Our ref: AN/2024/135611/07-  
L01

Your ref: EN010142

Date: 26 March 2025

**Order Granting Development Consent for the Tillbridge Solar Project  
(EN010142) - Examining Authority's third written questions.**

FIGURE TITLE
Watercourses, Flood Zones and Internal Drainage Boards (Sheet 1 of 3)

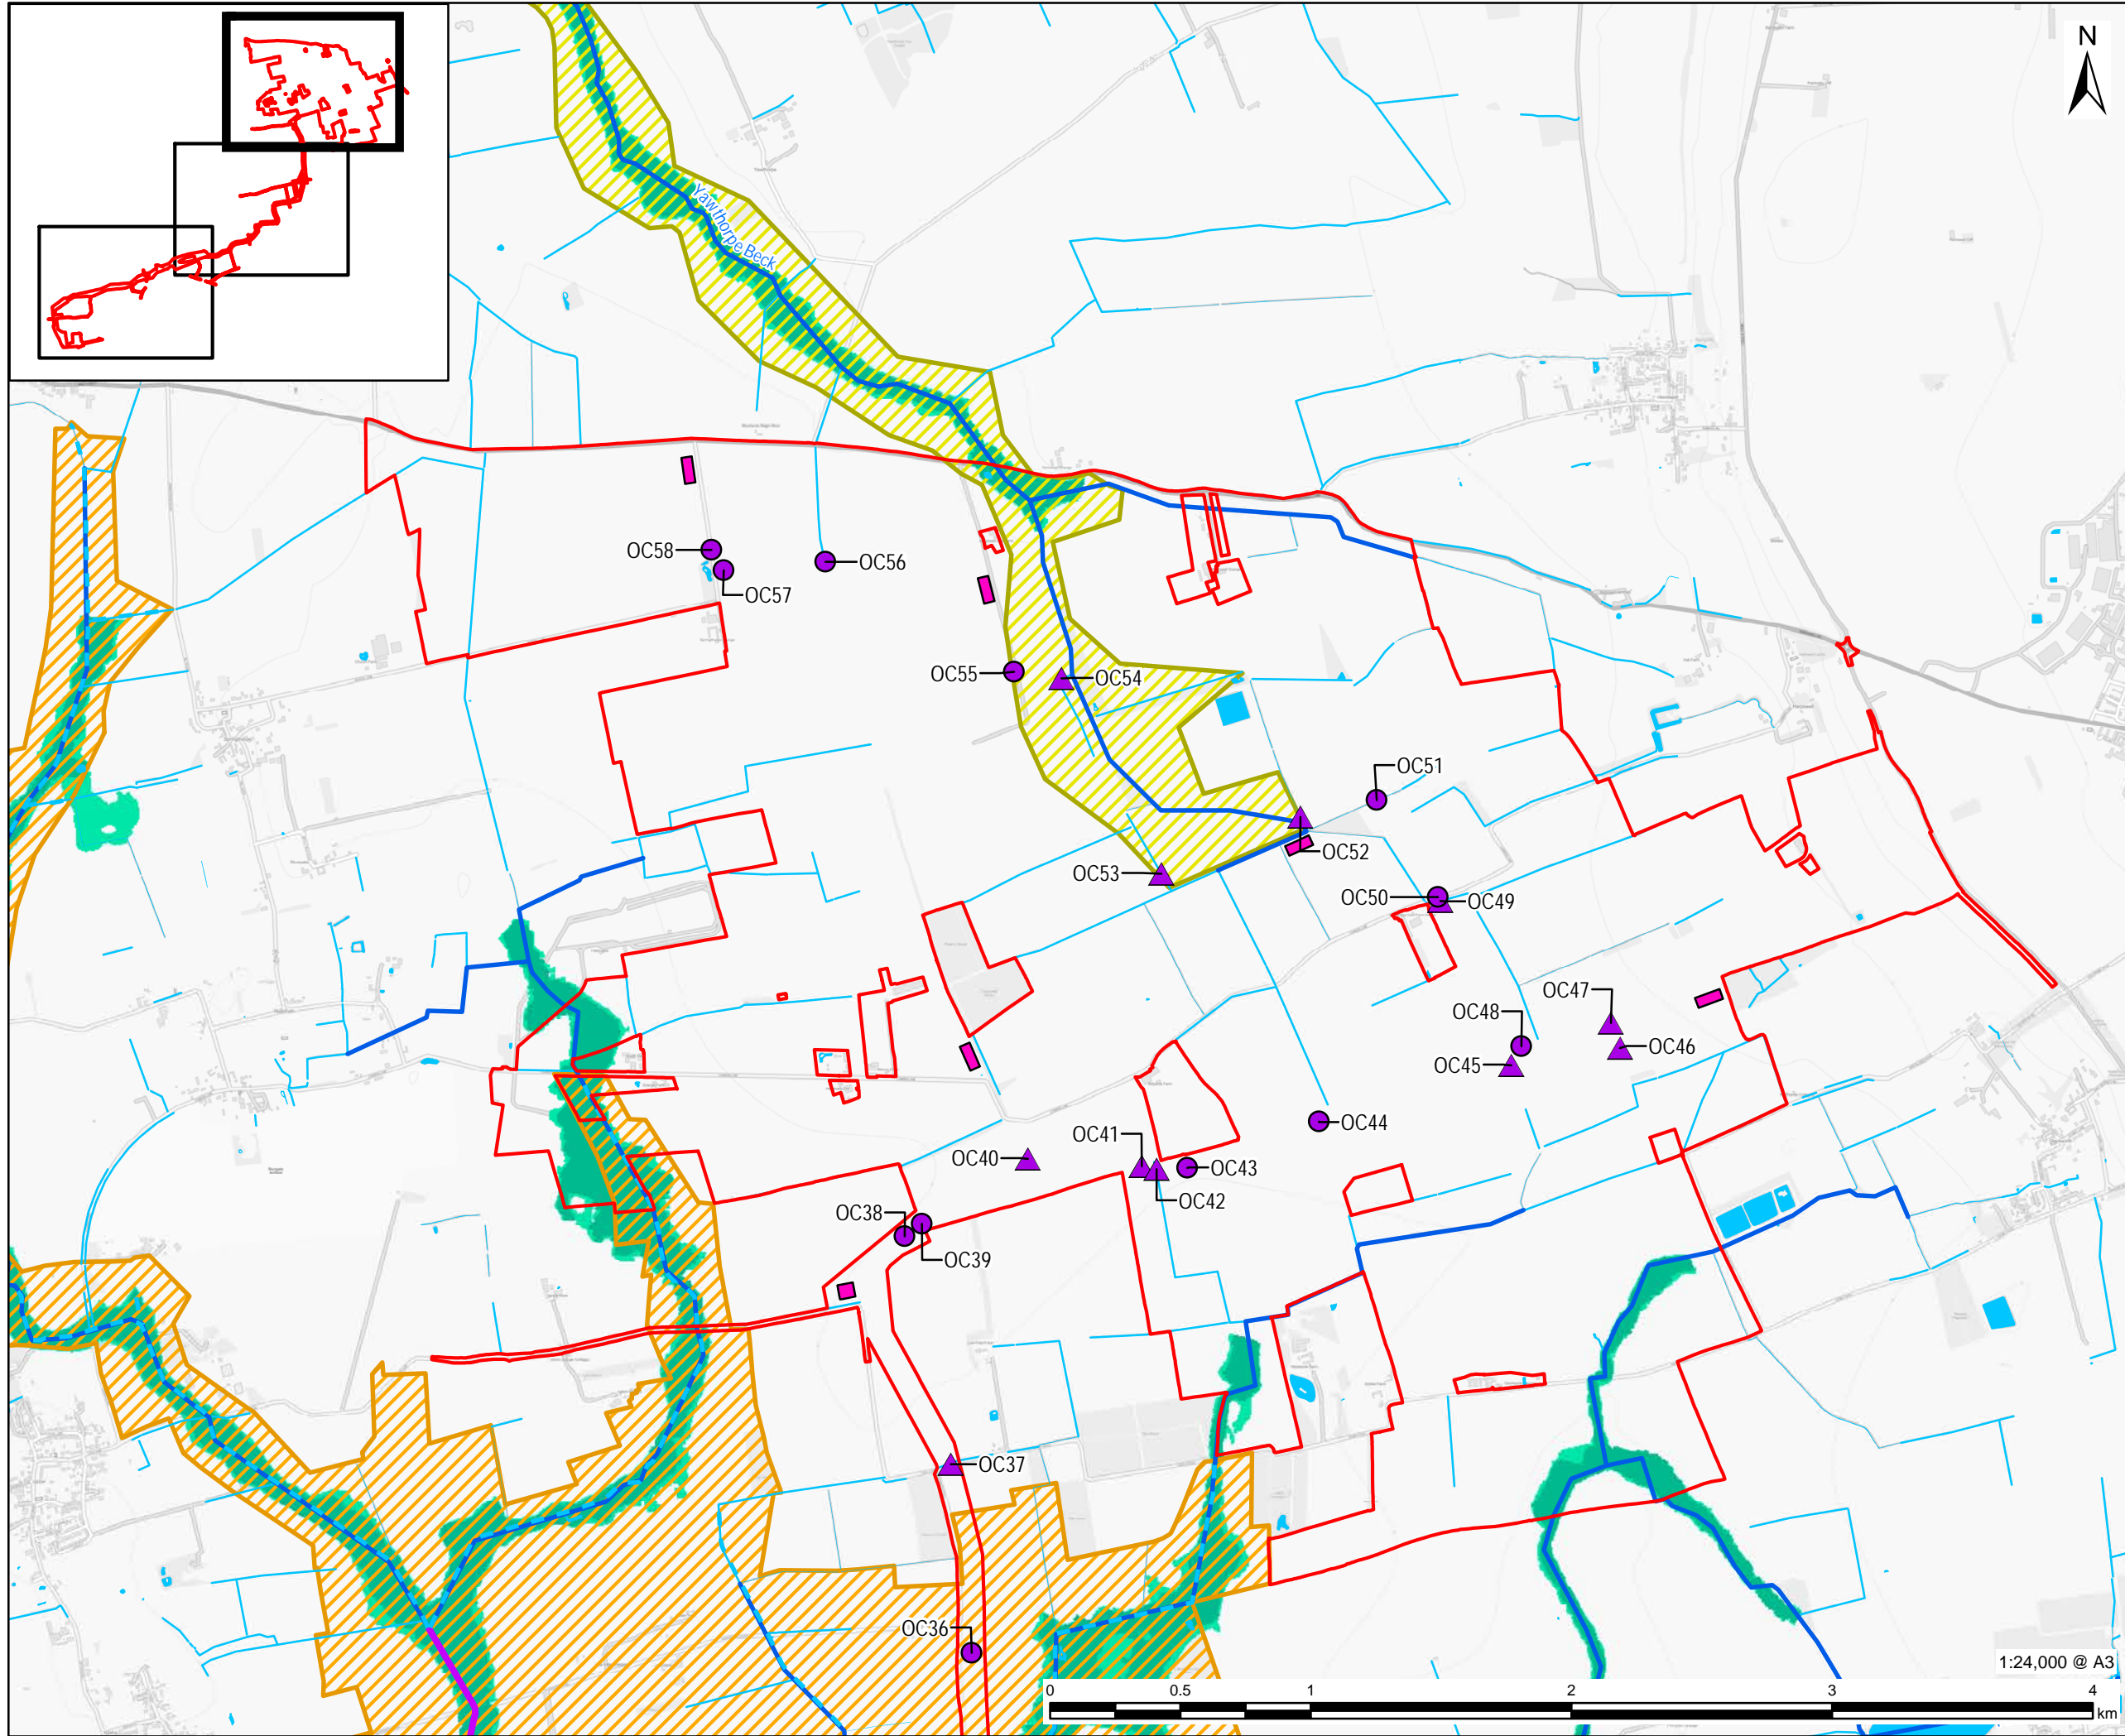
There are two areas of the Tillbridge Solar principal site where the flood zones change as a result of NaFRA2. These are the Harpswell Interaction Zone and an area near Westlands Farm.

In relation to Harpswell, the new flood extents show an increased area of risk which appears to affect solar panels in areas 56, 57, 70 and Principal Site Access 3

The area at Westlands Farm seems to include solar panel area 68.

The Environment Agency has considered this information and we agree with the applicants' comments on Fields 51, 56 and 57, Field 70, Field 77 and Field 68.

This is because the new extents are mainly very low chance and shallow depths <200mm. In addition, the flood risk is mainly located around the borders of fields and the impact on panels is limited.

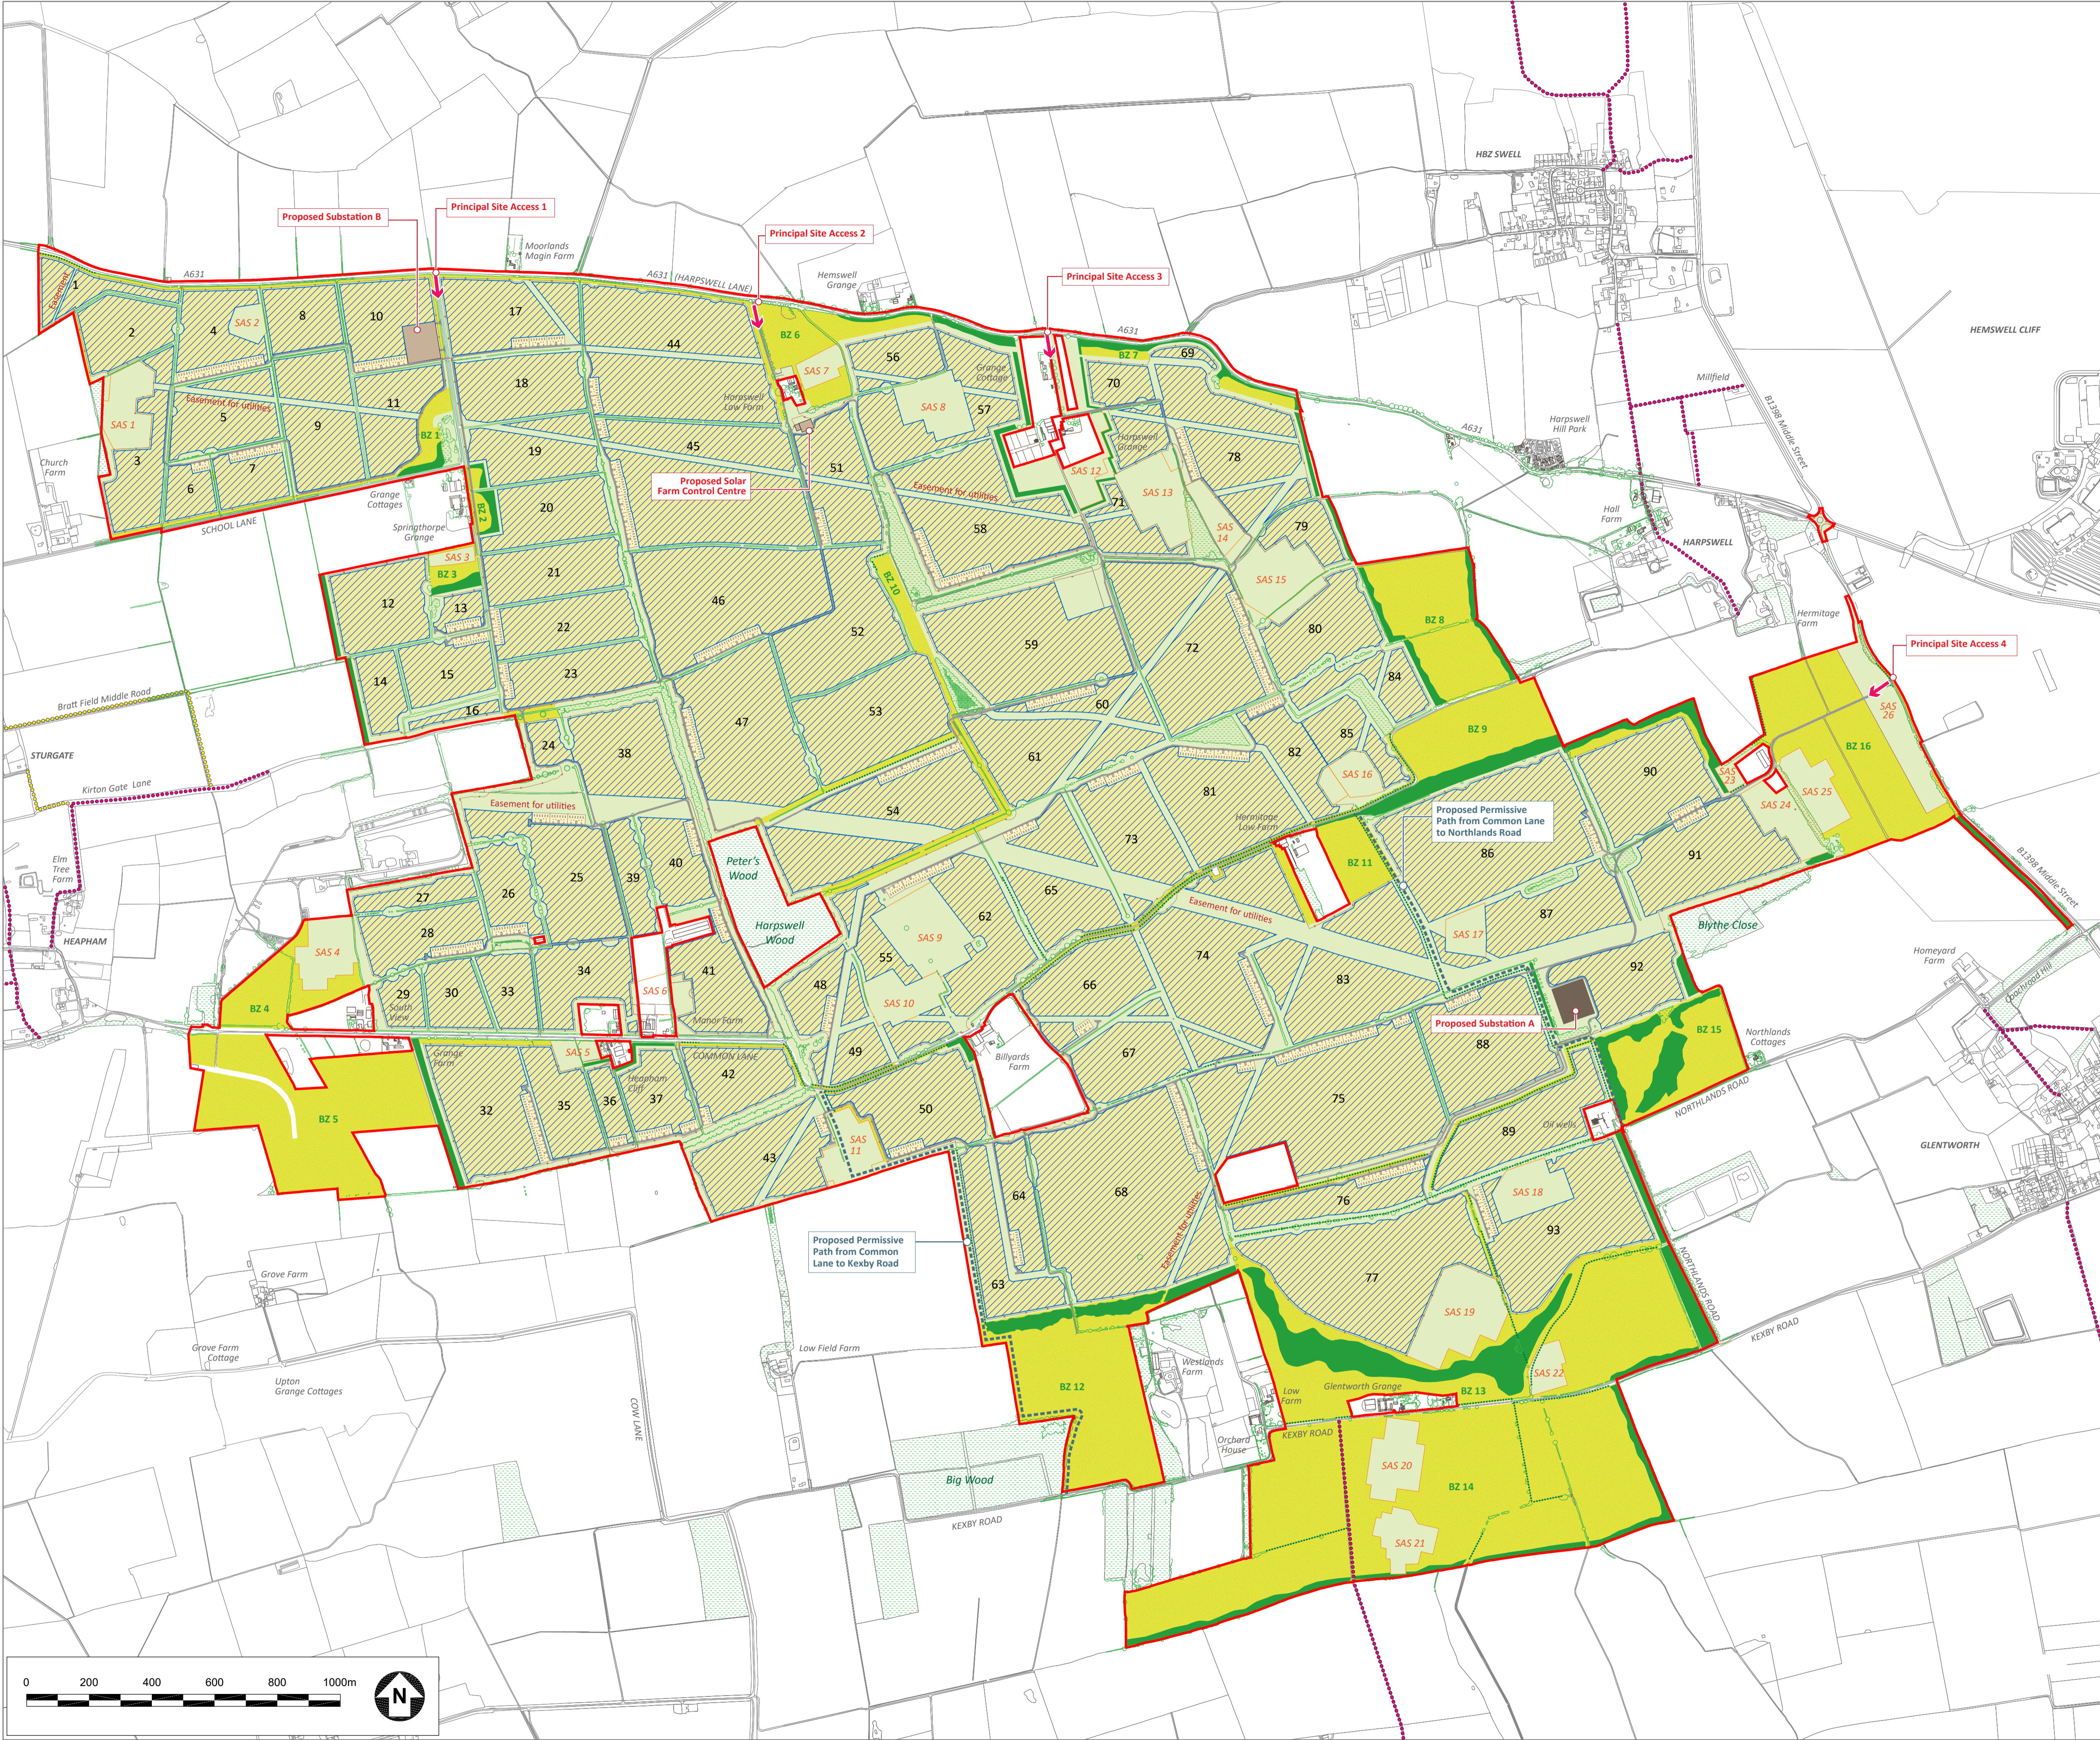
Finally, we note their comment on Principal Site Access 3 states the access will not impact on flood risk. We wish to clarify we are not concerned about the access's impact on flood risk here, rather the impact of flood risk on the access. Nevertheless, the depths are fairly shallow and the access track appears to be a natural boundary between the shallower and deeper flood risk. However, the applicant should be aware it may become impassable during flooding and we wish to make it clear that the route should not be used in the site Flood Warning and Evacuation Plans.

*The Applicant has reviewed the new National Flood Risk Assessment (NaFRA) dataset released by the Environment Agency and where the extended flood extents relate to the Principal Site and the indicative layout as presented on Figure 3-1: Indicative Principal Site Layout [EN010142/APP/6.3(Rev02)].*

Fields 51, 56 and 57	<b>Appendix 10-3: Flood Risk Assessment</b> of the ES [REP4-018] provided a detailed review of flood risk to these fields on the basis of which minimum solar panel height of 20.06m AOD within these fields were specified within the <b>Outline Design Principles Statement</b> [REP4-020]. The newly published flood mapping indicates a greater flood extent within Field 56, above 20.06m AOD; however, <b>Appendix 10-3: Flood Risk Assessment</b> of the ES [REP4-018] provides a more detailed assessment of flood risk to these fields, compared to the high-level mapping published for the Yawthorpe Beck. As such the assessment presented within <b>Appendix 10-3: Flood Risk Assessment</b> of the ES [REP4-018] is considered to remain valid.
Field 70	The updated NaFRA data indicate the extension of flood extents into Field 70. However, the flood extents only extend into areas of proposed landscaping, with no overlap with proposed solar infrastructure.

Principal Site Access 3	The updated NaFRA data indicate the extension of flood extents across Principal Site Access 3. This is an existing access that is proposed to be used during the operation of the Scheme only. No raising of ground levels is proposed at this location and as such, the use of the access for operational purposes will not impact on flood risk.
Field 77	From a review of the topographical survey and the mapping extents for flooding for up to the worst case extent, for up to 1.2m depth, the maximum depth the water would reach in this field is approximately 200mm; with panels set a minimum 600mm above ground level, it is considered mitigation to raise panels in Field 77 is not required.
Field 68	The lowest ground levels along the southern boundary of Field 68 fall from east to west, from 17.56m AOD, to 16.76m AOD. Comparing the topographical survey to the long term fluvial flood risk mapping, and applying the mapping extents for up to the worst case extent, for up to 1.2m depth, the maximum flood depths relative to the lowest perpendicular ground levels are no greater than 240mm (i.e. in cross section across the floodplain). With a minimum panel height of 600mm above ground, the flood depth at any given point for solar PV panels in Field 68 will not reach the base of the panel with at least 300mm freeboard still afforded. Therefore, it is considered no mitigation is required within Field 68.

On this basis, we are happy that the new NaFRA2 data has been taken into account in considering this development.
